<b>Application Ref:</b>	3/2026/0073			 Ribble Valley Borough Council <small>www.ribblevalley.gov.uk</small>
<b>Date Inspected:</b>	11/2/26	<b>Site Notice:</b>	11/2/26	
<b>Officer:</b>	BT			
<b>DELEGATED ITEM FILE REPORT:</b>				<b>APPROVAL</b>

<b>Development Description:</b>	Conversion of a redundant barn to an affordable local needs occupancy residential dwelling. Installation of a package treatment unit.
<b>Site Address/Location:</b>	Poor Parts Barn, Hellifield Road, Bolton-By-Bowland, BB7 4LU.

Proposed Front Elevation
Scale (1:100)

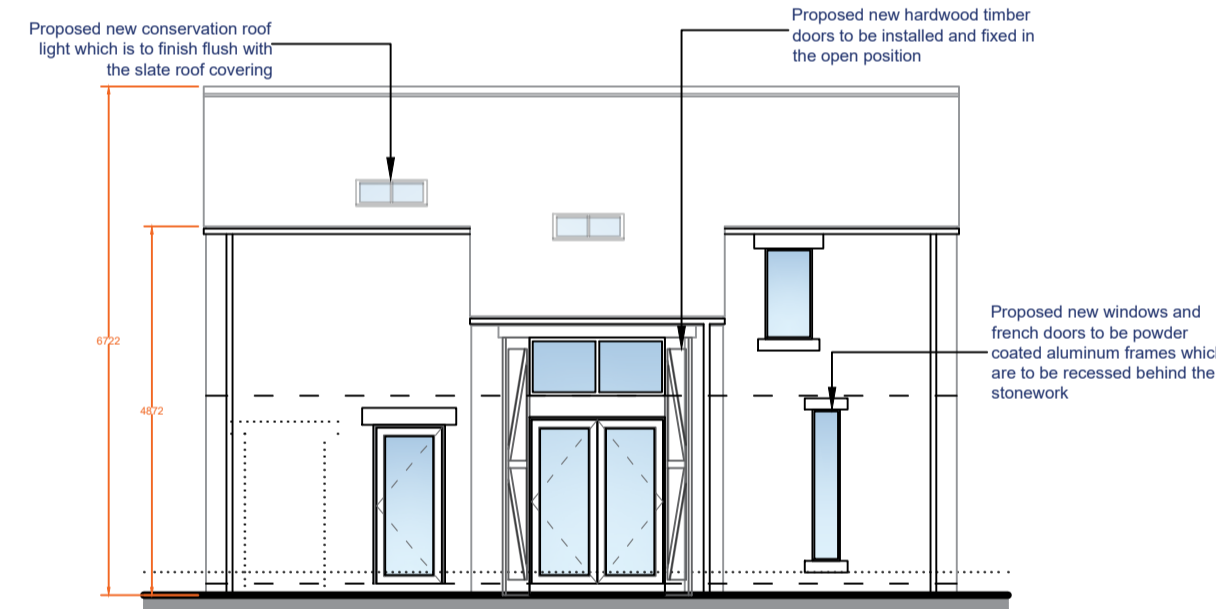
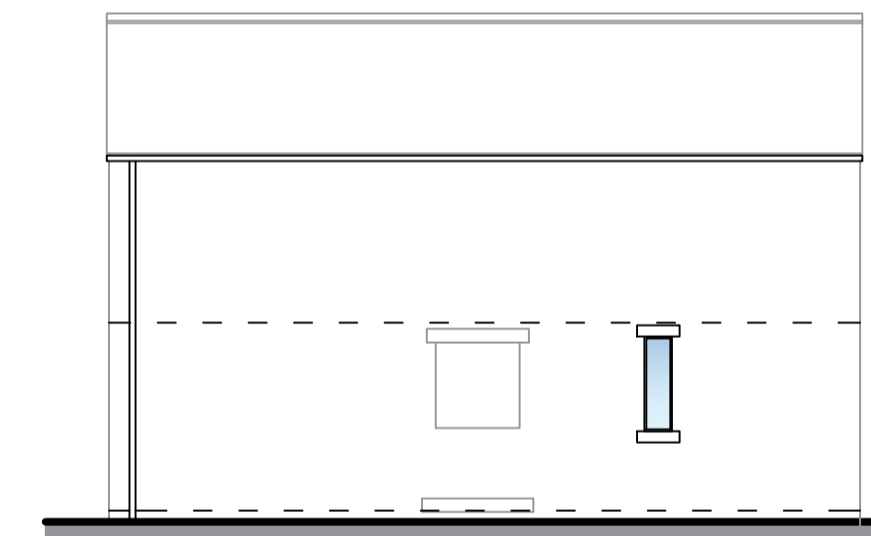
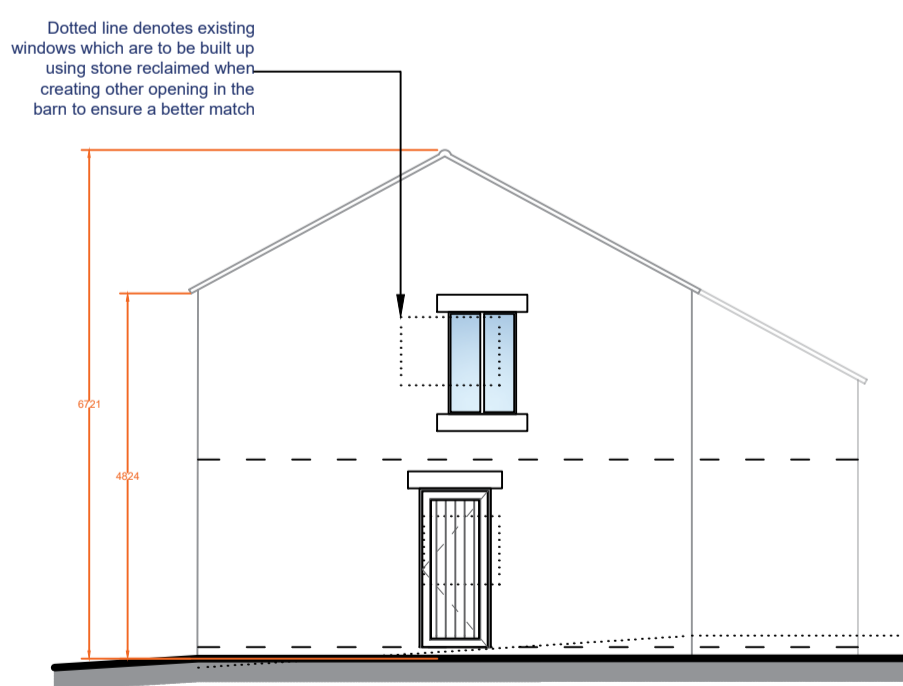
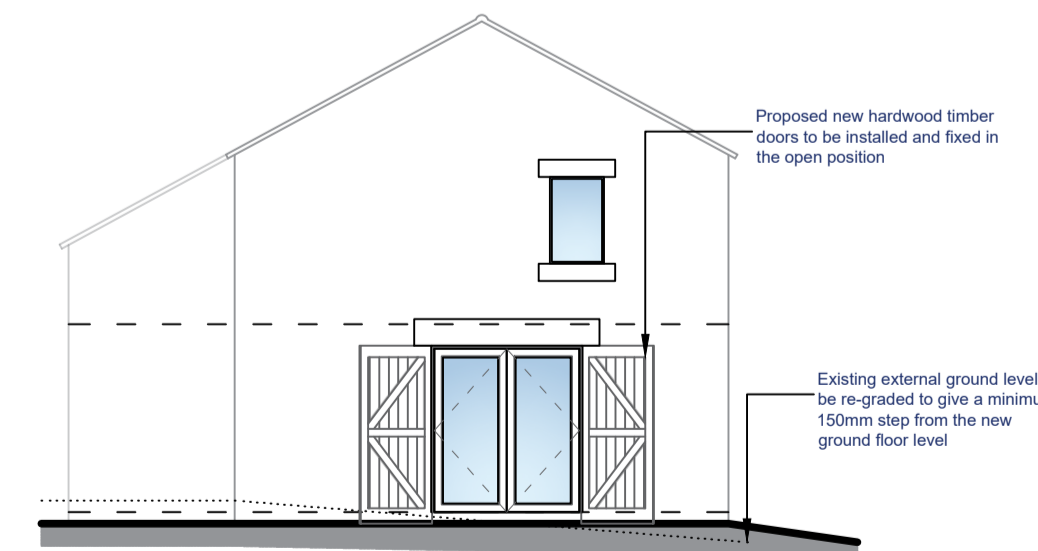
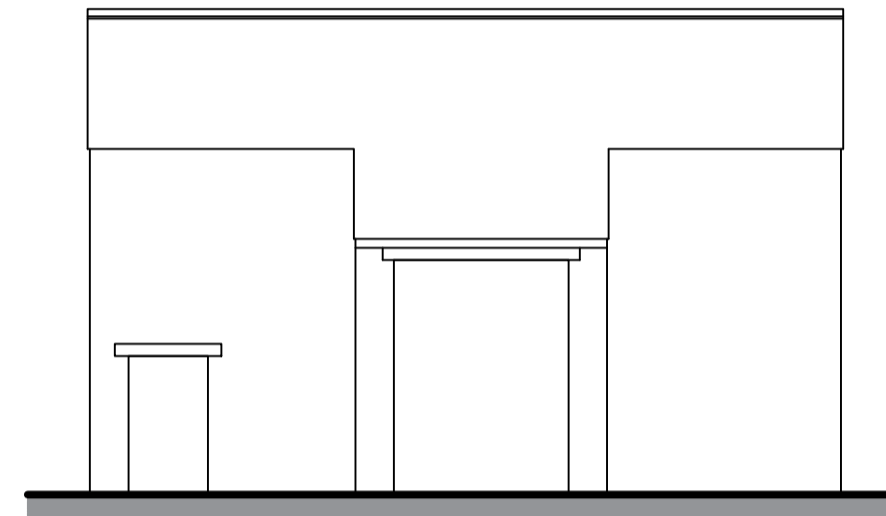
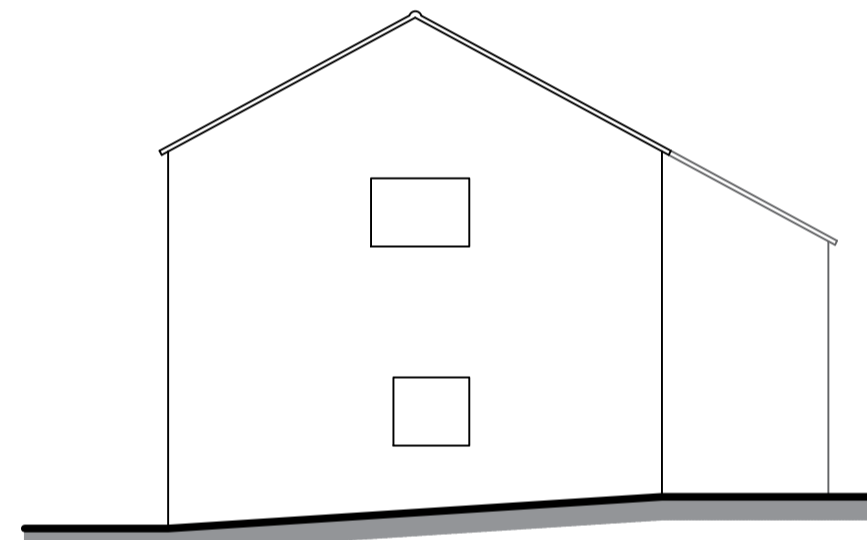
In this instance, the proposed conversion would involve the introduction of several new window and door openings to the historic barn building, with only one existing opening utilised as part of the proposed works. Several of the barn's historic openings would also be obscured and infilled as part of the proposed conversion, with several of the proposed window, door and rooflight openings not serving habitable rooms. Furthermore, the proposed site plan submitted in support of the application denotes a sizeable area of domestic curtilage area to serve the proposed dwelling with this encroaching well into the agricultural fields well beyond the South-western building line of the barn. Consequently, the proposed development, by virtue of the unjustified insertion of new window openings (which would also occur at the expense of sacrificing historic openings within the barn building) and subsequent loss of historic building fabric is considered to be predominantly at odds with the well-established approach to converting historic farm buildings quoted above in as much that little attempt has been made to conserve the significance of the historic barn building. Moreover, the application property occupies an isolated location in full public view from Hellifield Road therefore the visual impact of the proposed development would be pronounced.

Furthermore, the proposed development, by virtue of the unjustified insertion of new window openings into the historic barn building, subsequent loss of historic building fabric, closure and obscurement of historic openings and resultant encroachment into the surrounding open countryside would amount to an incongruous and unsympathetic form of development which would have a harmful urbanising impact that would neither enhance or conserve the visual amenities of the surrounding National Landscape. The proposed development would therefore fail to satisfy the requirements of Paragraph 135 (c) and 189 of the NPPF and Key Statement EN2 and Policy DMG1 of the Core Strategy.
